Rezoning Transportation Analysis

Petition Number: 2020-45

General Location Identifier: Parcels 09104101, -02, and -03 on Bearwood Ave.

**Bearwood Ave
Rezoning Site Plan**

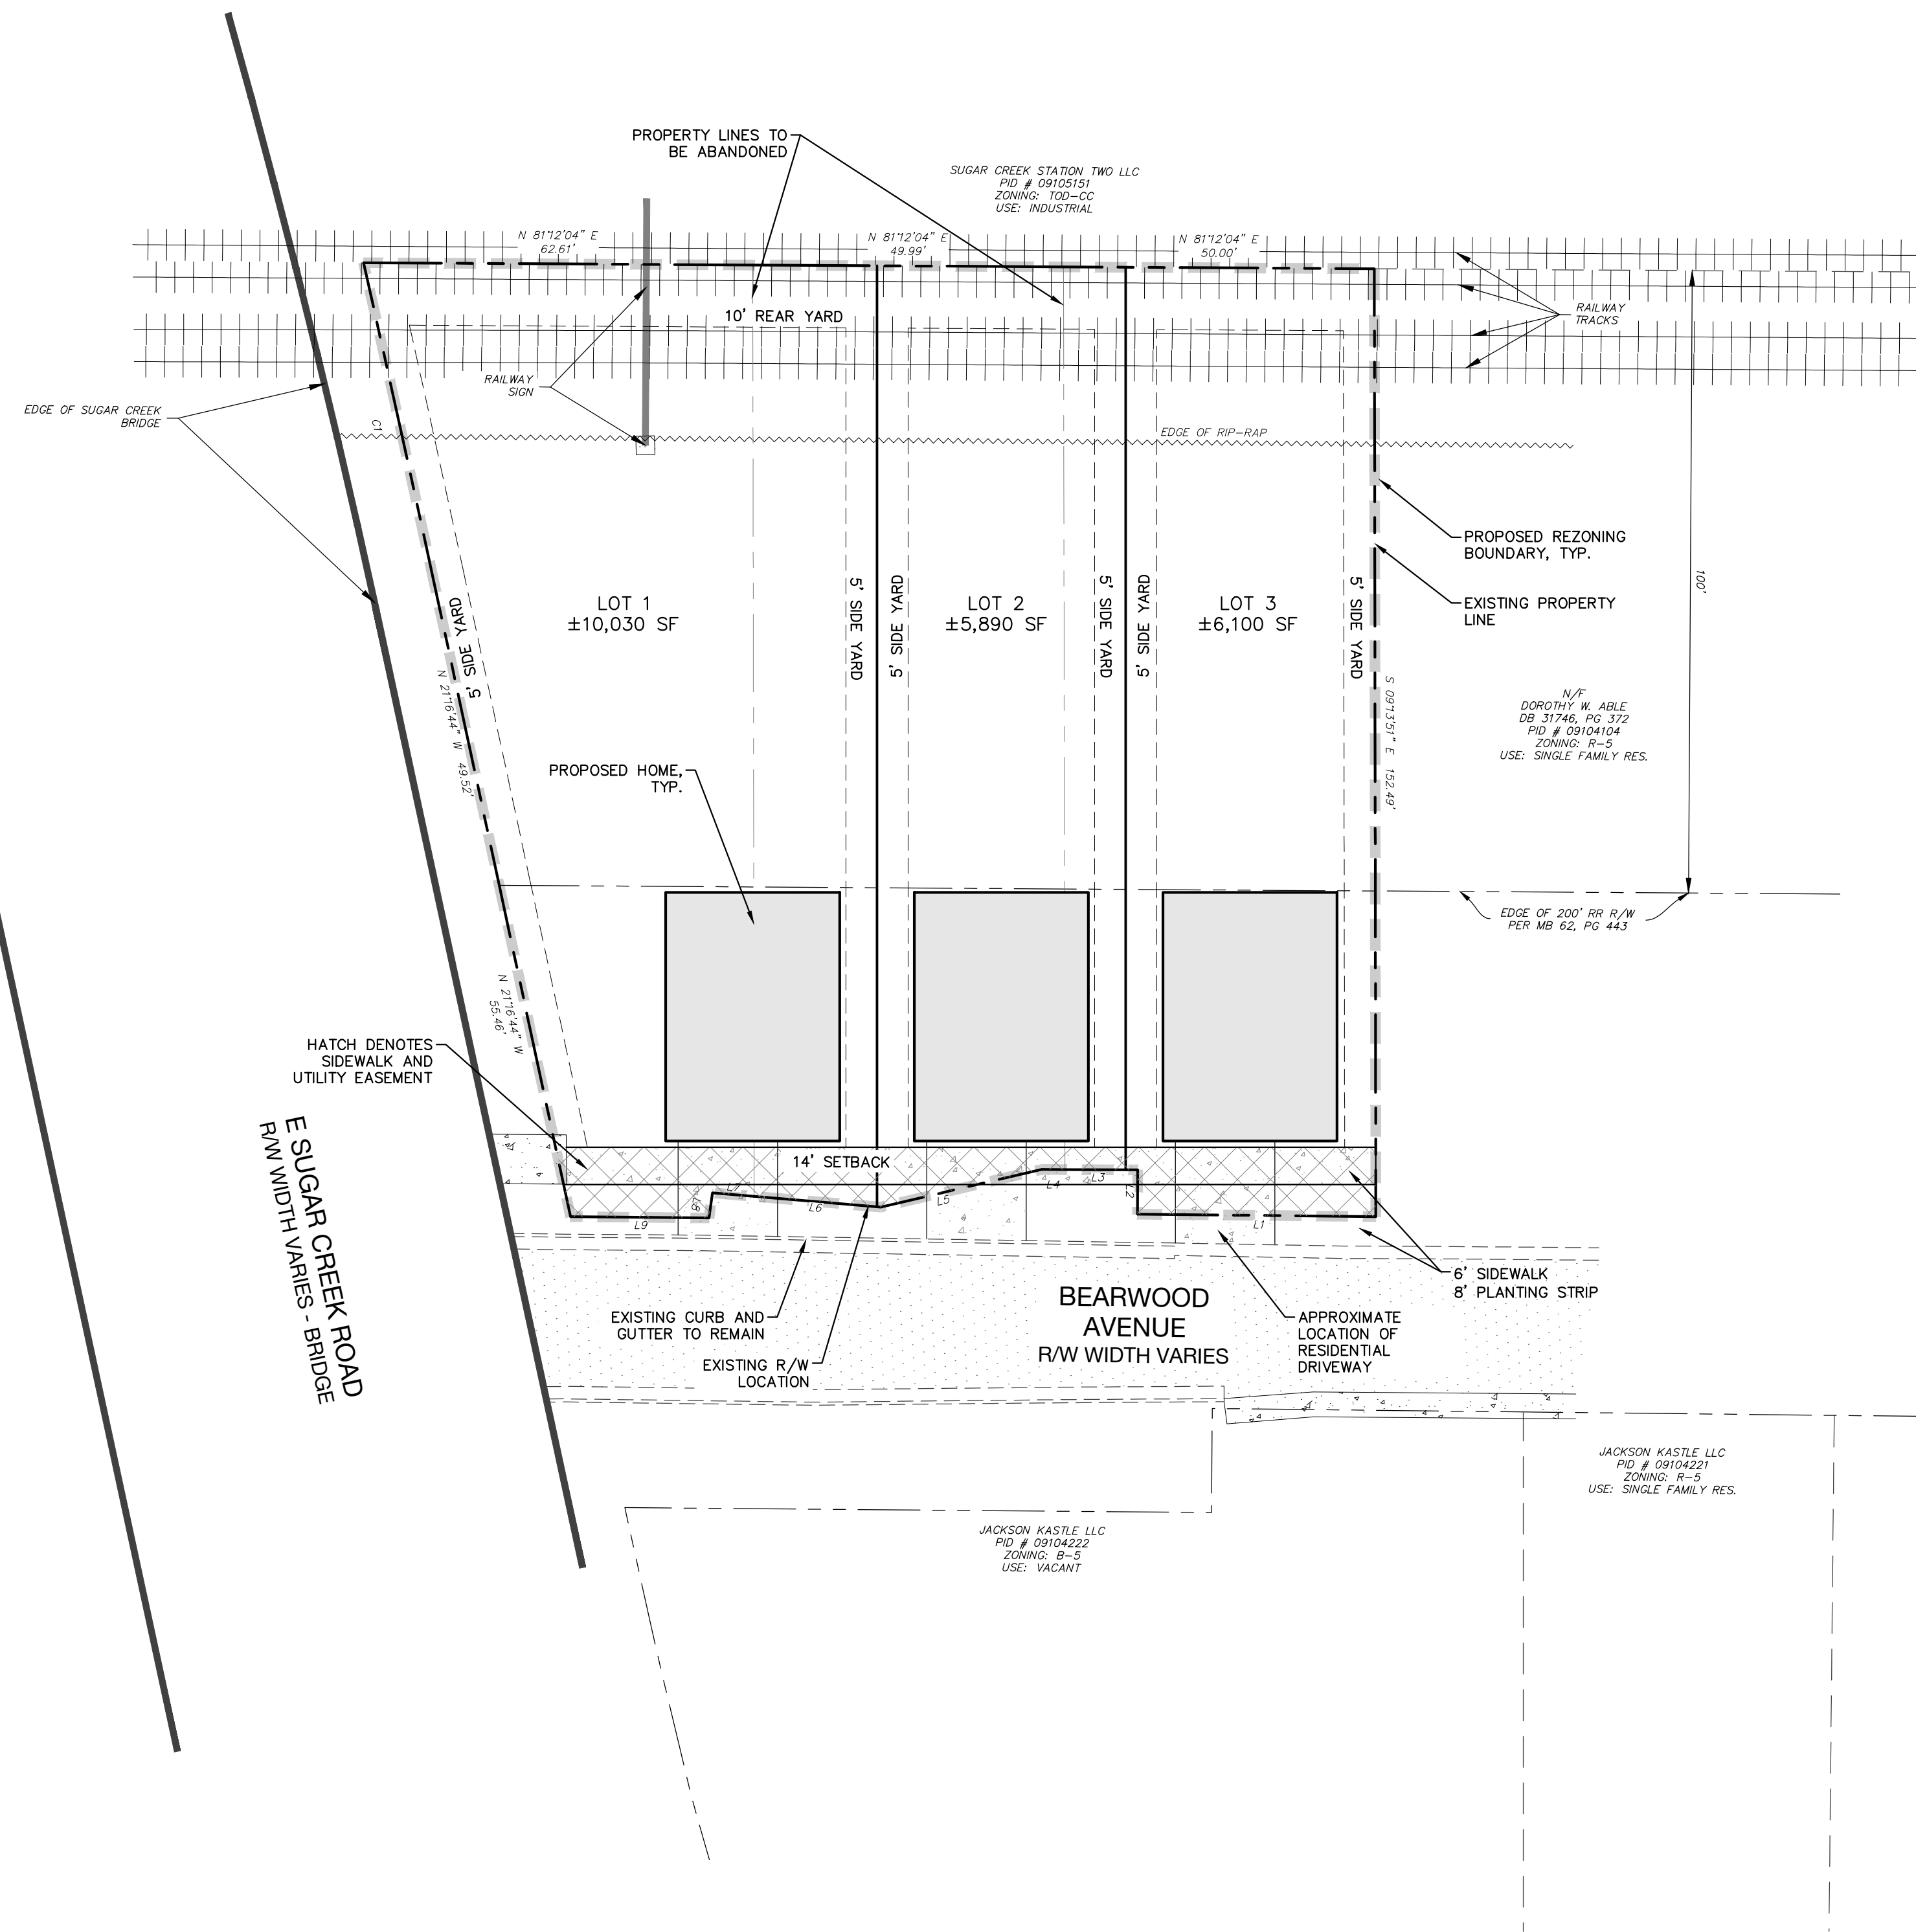
The site plan should show the curb and gutter labeled and dimensioned from the centerline for each road.
- ~~2. **Traffic Study** A Traffic Impact Study is not necessary for the complete review of this petition. If the during the permitting process the site generates more than 2,500 daily trips, then a traffic study will be required.~~

- ~~3. The right-of-way line for Bearwood Ave. should be revised to be a consistent dimension from centerline.~~
- ~~4. The petitioner should revise the site plan and conditional note(s) to adjust the proposed building footprints to ensure that there is a minimum of 20 feet from the garage to the back of sidewalk or back of right-of-way, whichever is greater, as required by the Zoning ordinance. If the railroad right-of-way precludes adjustments to building footprints, suggestions for providing parking include providing shared parking in the rear of Lot 1, and providing recessed parallel parking on Bearwood Ave.~~

- ~~5. The petitioner should revise the site plan to add a note specifying dedication and fee simple conveyance of all rights of way to the City before the site's first building certificate of occupancy is issued. CDOT requests right of way set at 2' behind back of sidewalk where feasible.~~
